**Response to Planning application from Hertfordshire County Council (T and CP GDP Order 2015)**

District ref: 6/2023/1124/FULL  
HCC ref: WH/17057/2023  
HCC received: 13 July 2023  
Area manager: Manjinder Sehmi  
Case officer: Senober Khan

2 Hill Rise Cuffley Potters Bar EN6 4EE

Erection of 5 bedroom dwelling following the demolition of existing dwelling

Site Plan 1:200 Scale

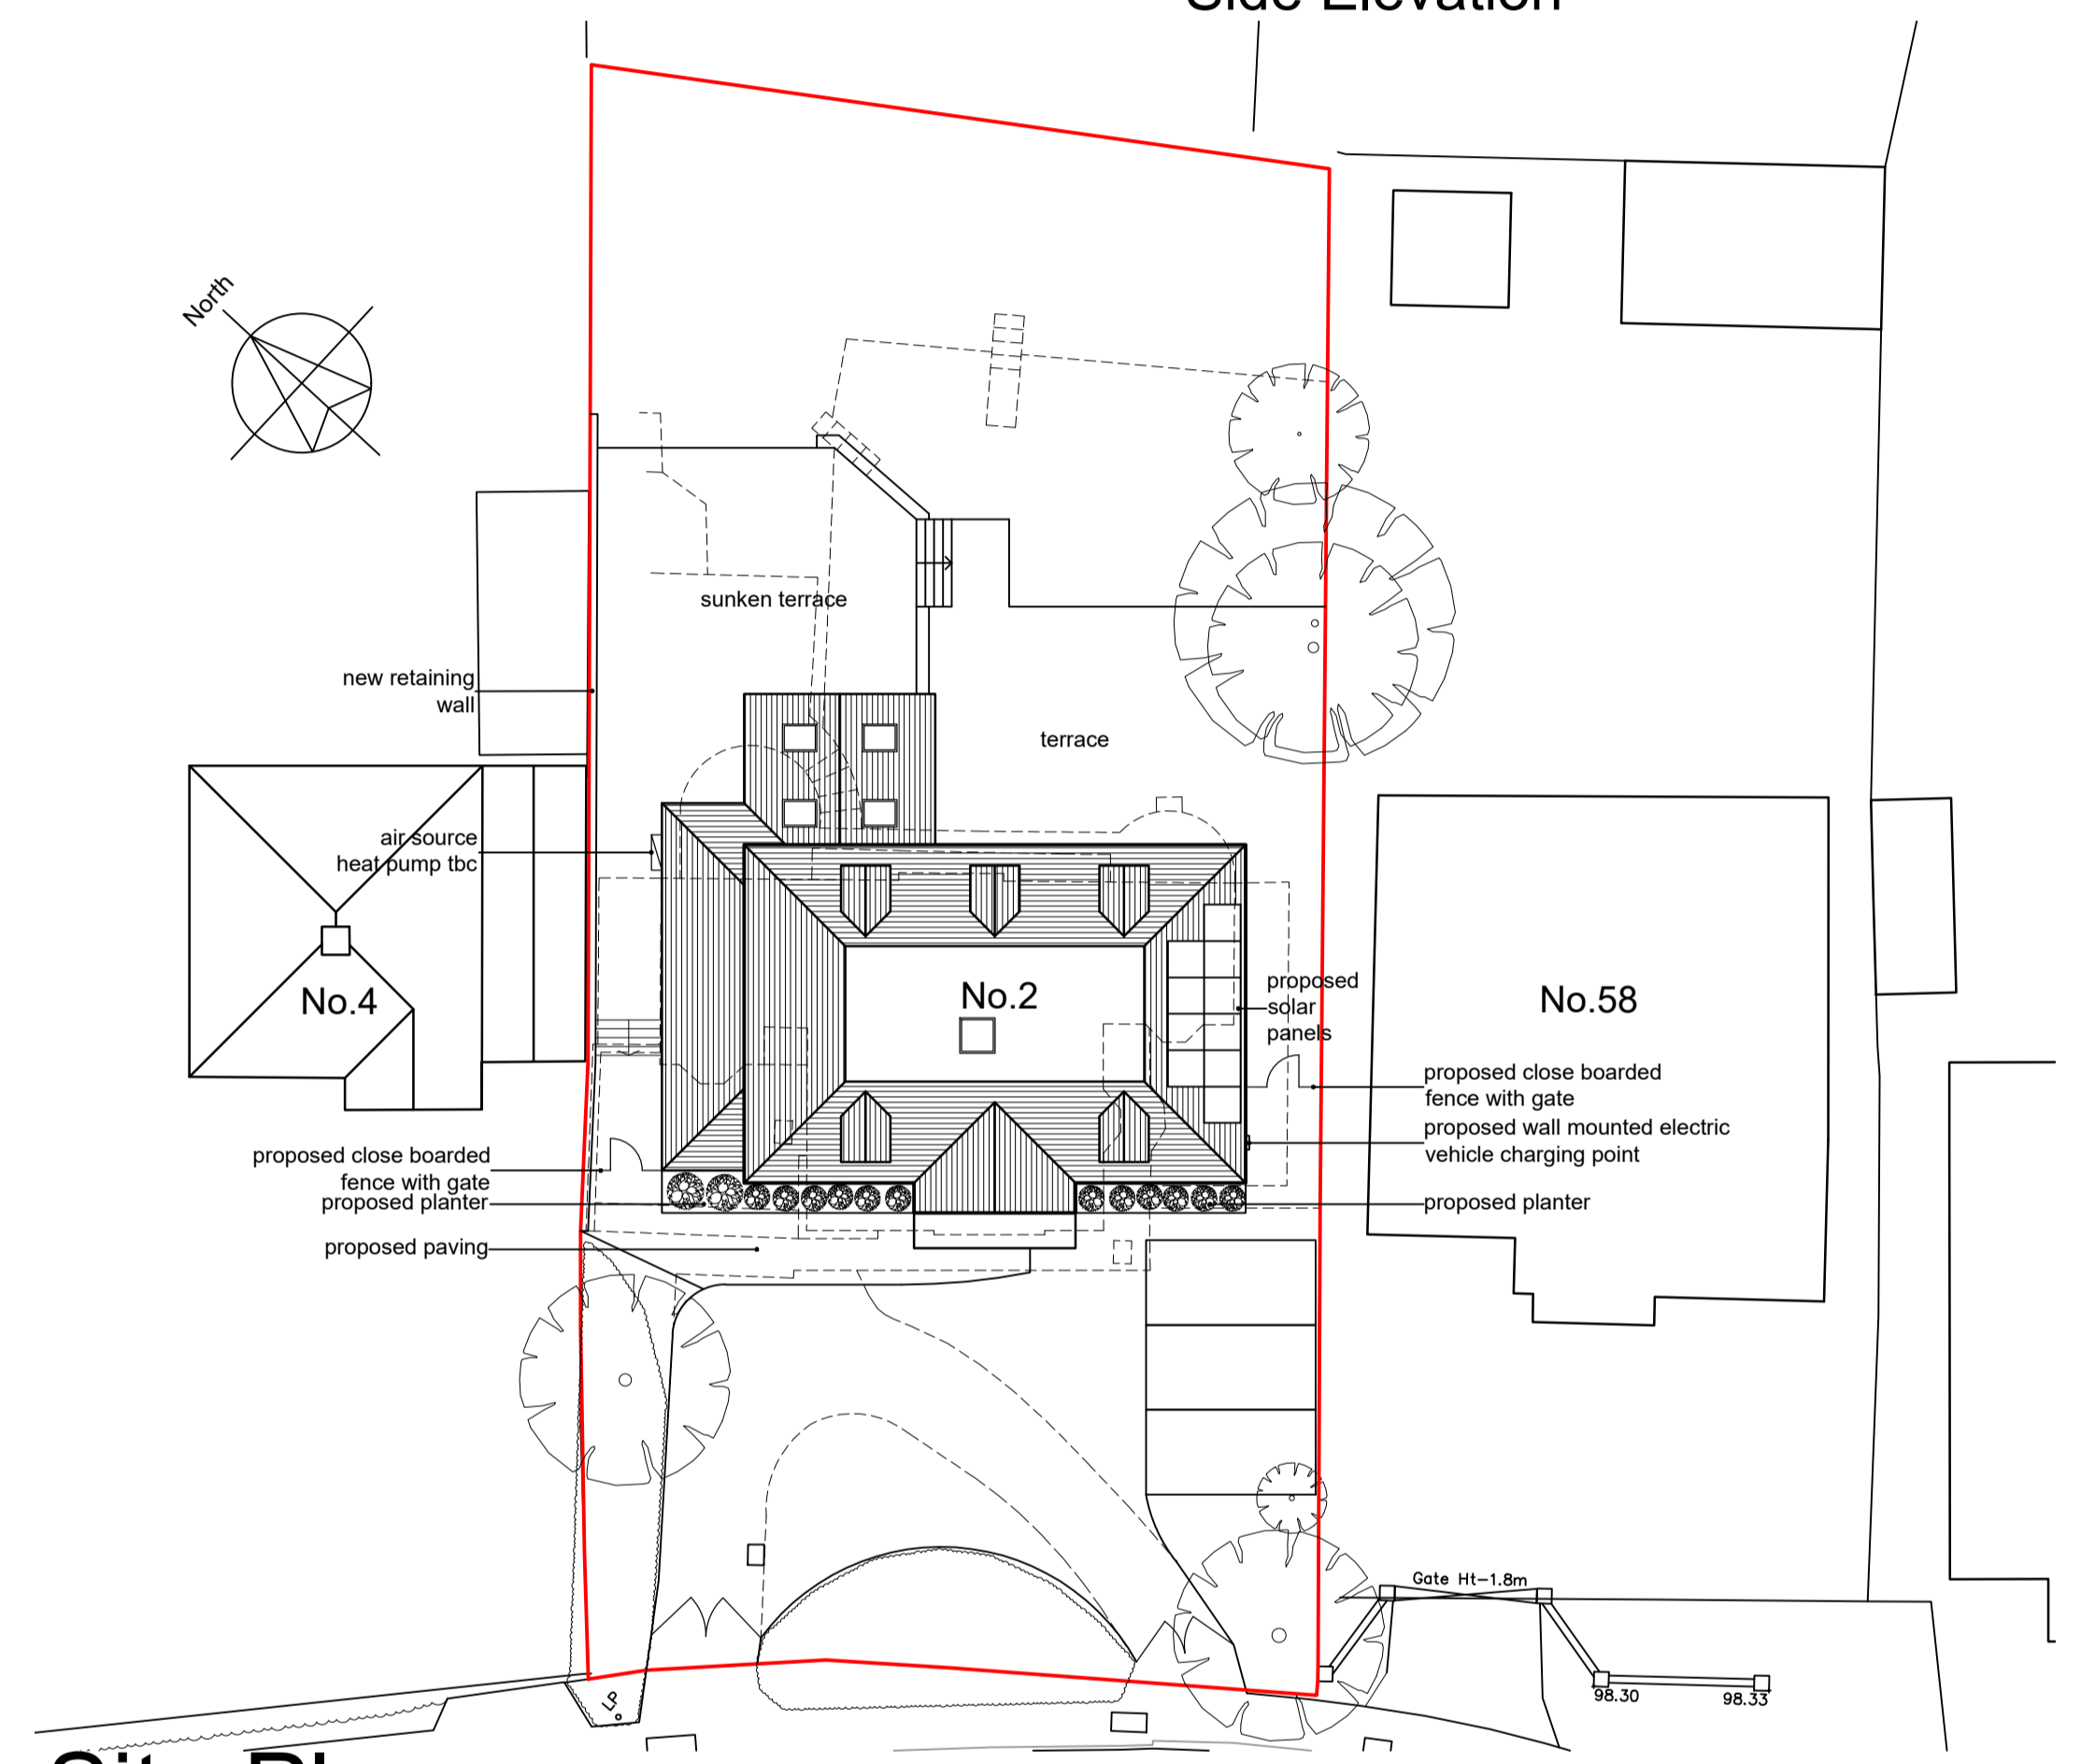
In response to the HA's comments dated 28 June 2023, the applicant has submitted an amended proposed site plan (drawing no.20536-P002-1st) which shows the applicant continues to retain the

northern vehicle access opposite the junction of Hill Rise with The Driveway, 2m x 2m pedestrian visibility splays, the gate set back annotated 5.5m back from the kerb, existing vehicle access as pedestrian access only gate and EV charge points at the car parking bays.

For reasons explained in the HA's previous comments the use of the existing northern vehicle access instead of the southern vehicle access is not supported.

The applicant has incorrectly shown the siting of the pedestrian visibility splays, as stated in the HA's previous comments the splays should be from the back of the public highway, which in this case should be from where the red line boundary of the site meets the vehicle driveway as shown on the submitted drawing. The applicant is responsible for and should remove any foliage encroaching onto the public highway from the applicant's site.

The same applies to the proposed gate, it should be set back 5.5m from where the sites red boundary line meets the public highway and not from the kerb.

The closure of either of the existing vehicle access will result in the redundancy of the crossover, the applicant will be liable for the cost of returning the redundant second dropped kerb/crossover fronting the site along Hill Rise back to footway, this should be shown and annotated on the deposited plans.

The applicant has shown on the amended plan an EV pedestal and a cycle store without substantiating how the provision and storage/layout is compliant with HCC design and layout/ Cycle Design Guidance (2020, DfT).
